**State Significant Development No. SSD-8375**  
**Stop the Clock - Request for additional information**

I refer to the above application (the application) which was received by the EPA on 4 November 2019 for comment by the Department of Planning, Industry and Environment (DPIE). The Applicant, Autorecyclers Pty Ltd is seeking development approval from DPIE to expand the current facility to process 130,000 tones of scrap metal per year at 57-69 Tattersall Road, Kings Park (Lot 100 DP 792731).

The EPA has undertaken a preliminary assessment of the application including a detailed Environmental Impact Statement by Barker Ryan Stewart dated October 2019 and has concluded that there is insufficient information to adequately assess the application and provide General Terms of Approval.

- BUILDING A - ADMINISTRATION
- BUILDING B - PROCESSING
- BUILDING C - ELV FACILITIES / VEHICLE PARTS STORAGE
- BUILDING D - ELV FACILITIES / VEHICLE PARTS STORAGE
- BUILDING E - YARD OFFICE AND PUBLIC ACCESS FOR PICK N PAYLESS
- BUILDING F - INDUSTRIAL SHED
- BUILDING G - INDUSTRIAL SHED

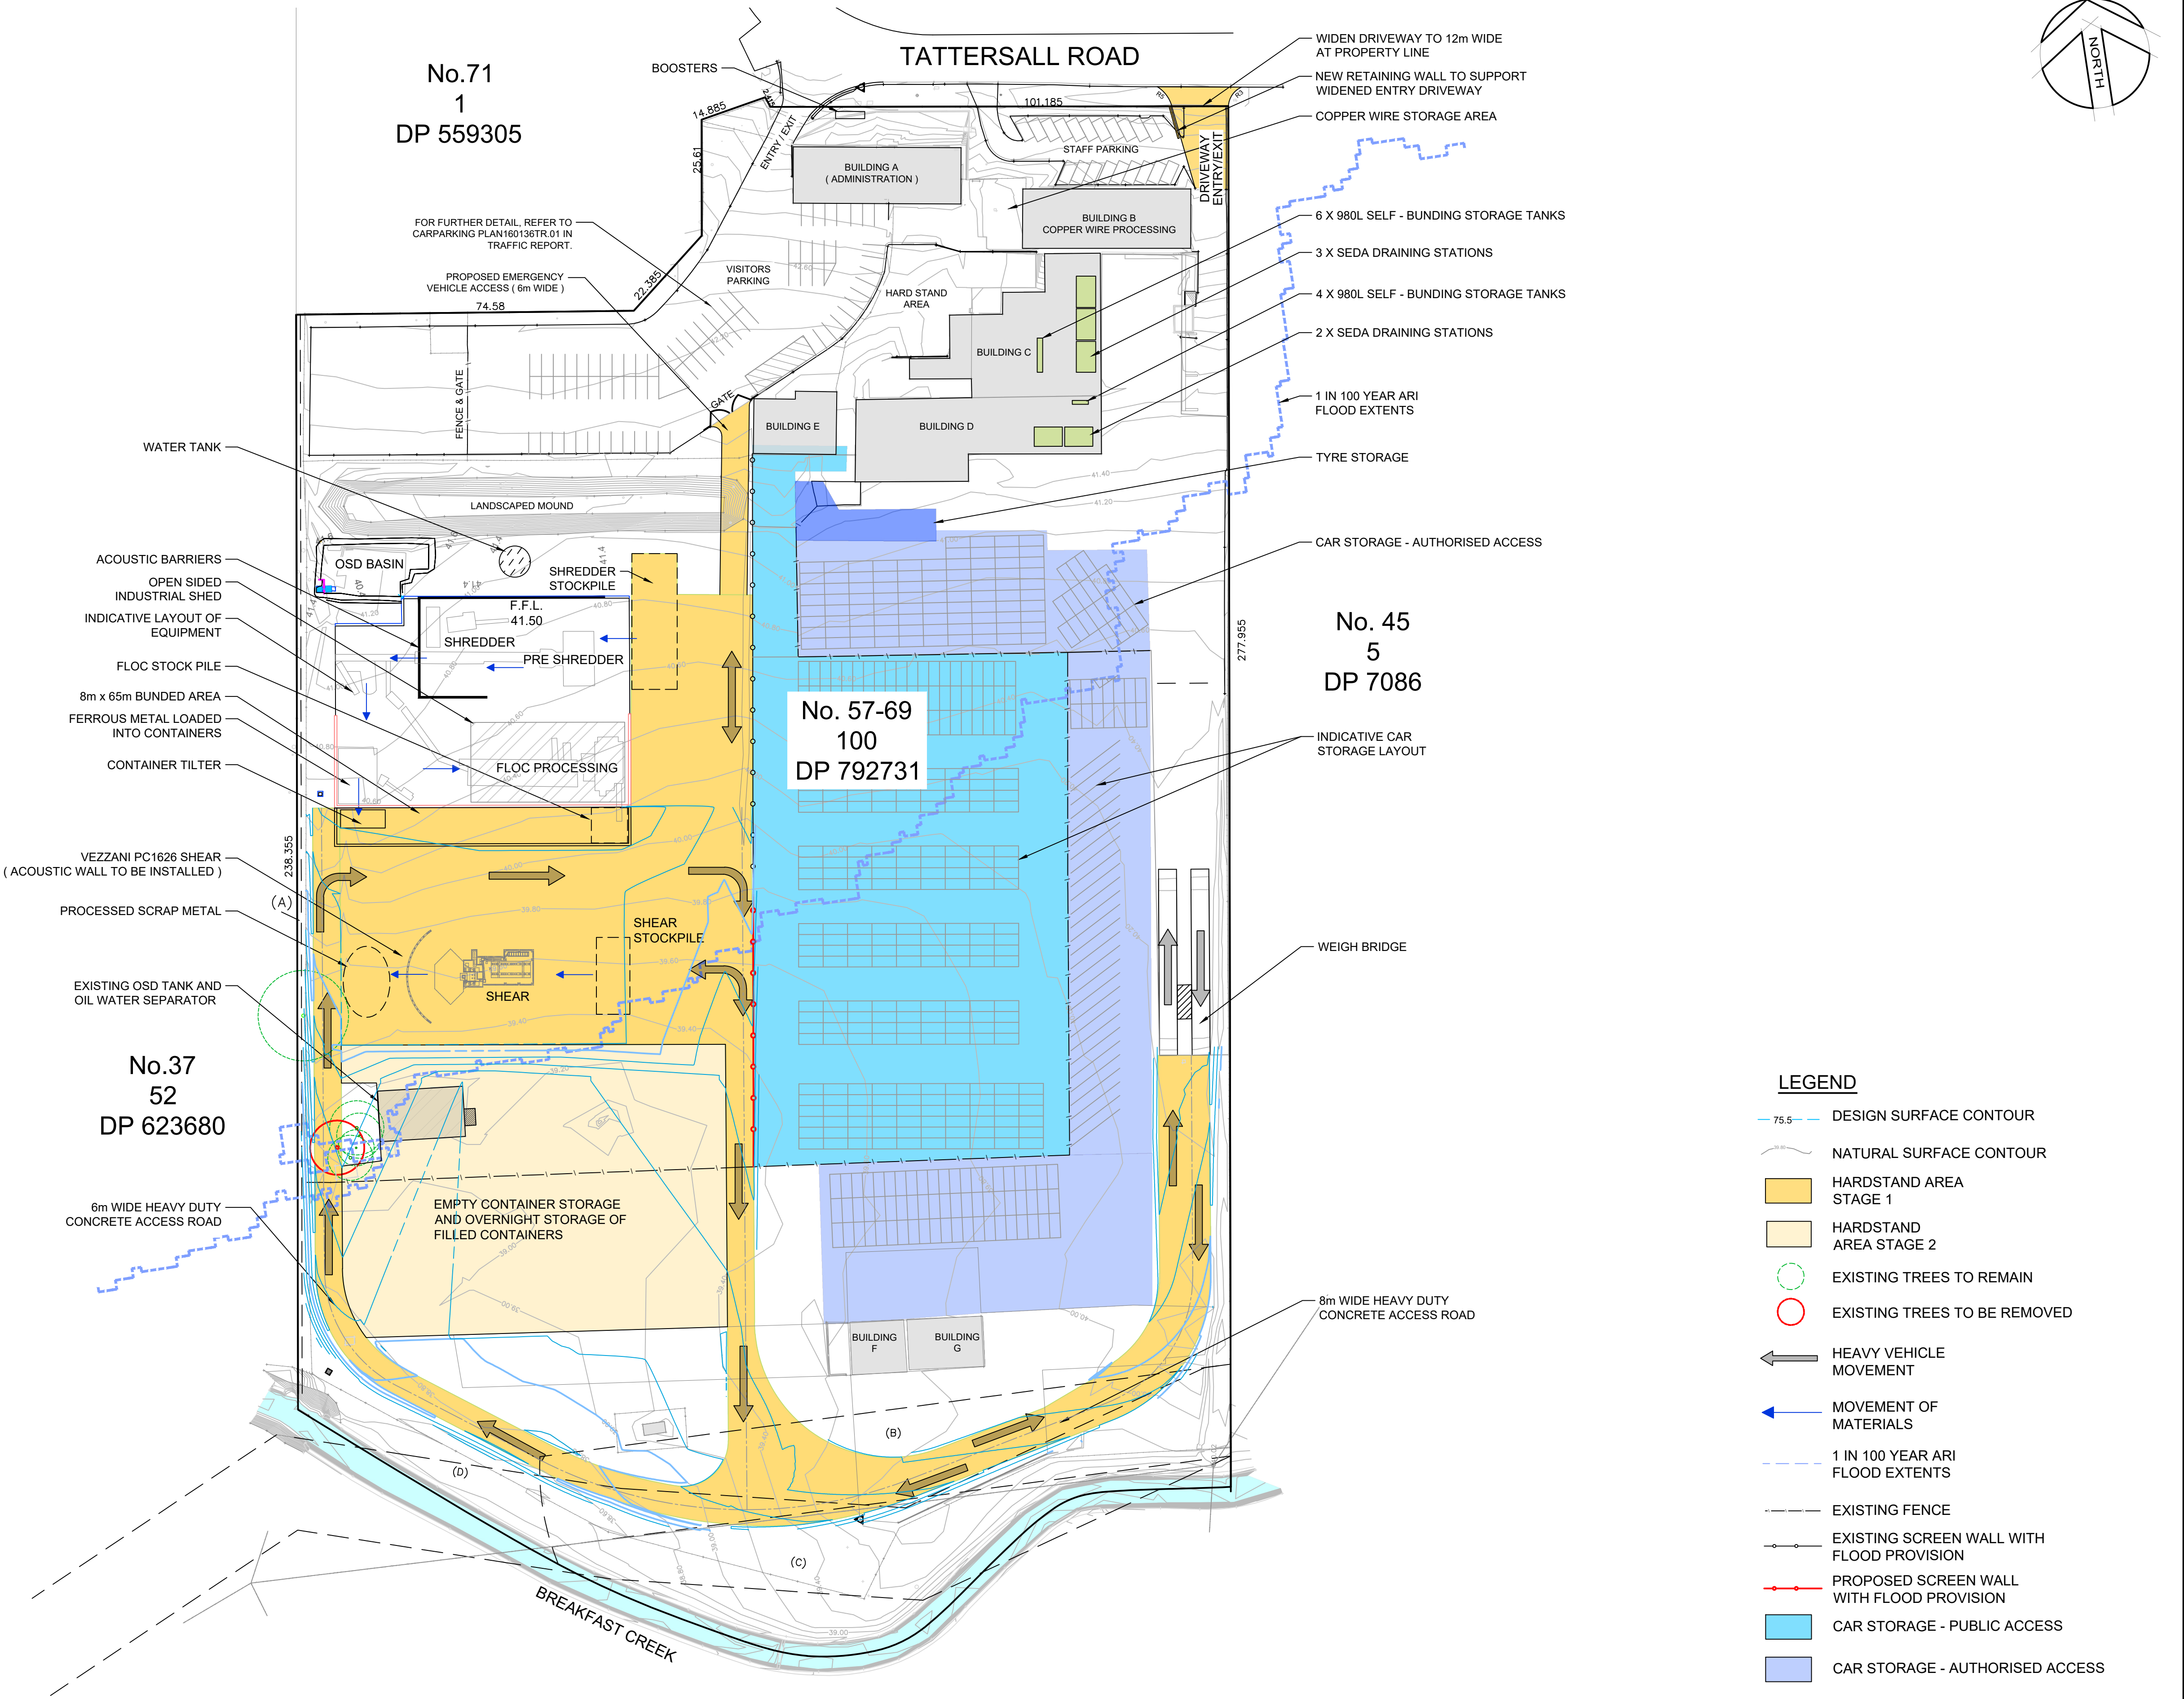
The EIS does not provide adequate detail of the proposed water management system to demonstrate that the potential water quality risks will be appropriately managed. The *Site Plan* at Appendix B provides a proposed drainage plan for the southern part of the premises only and the *Catchment Plan* at Appendix B does not cover the entire site.

*It is recommended that the applicant provides a site drainage plan for the entire premises. The plan should:*

- *define site sub-catchment boundaries*
- *identify 'clean', 'dirty' and contaminated runoff sub-catchments*
- *identify the location and provide details of all potential water pollution sources including but not limited to processing and storage areas*
- *indicate surface flow directions*
- *include all water management features including pits, pipes, drains, bunds, storages, treatment measures and proposed discharge points.*
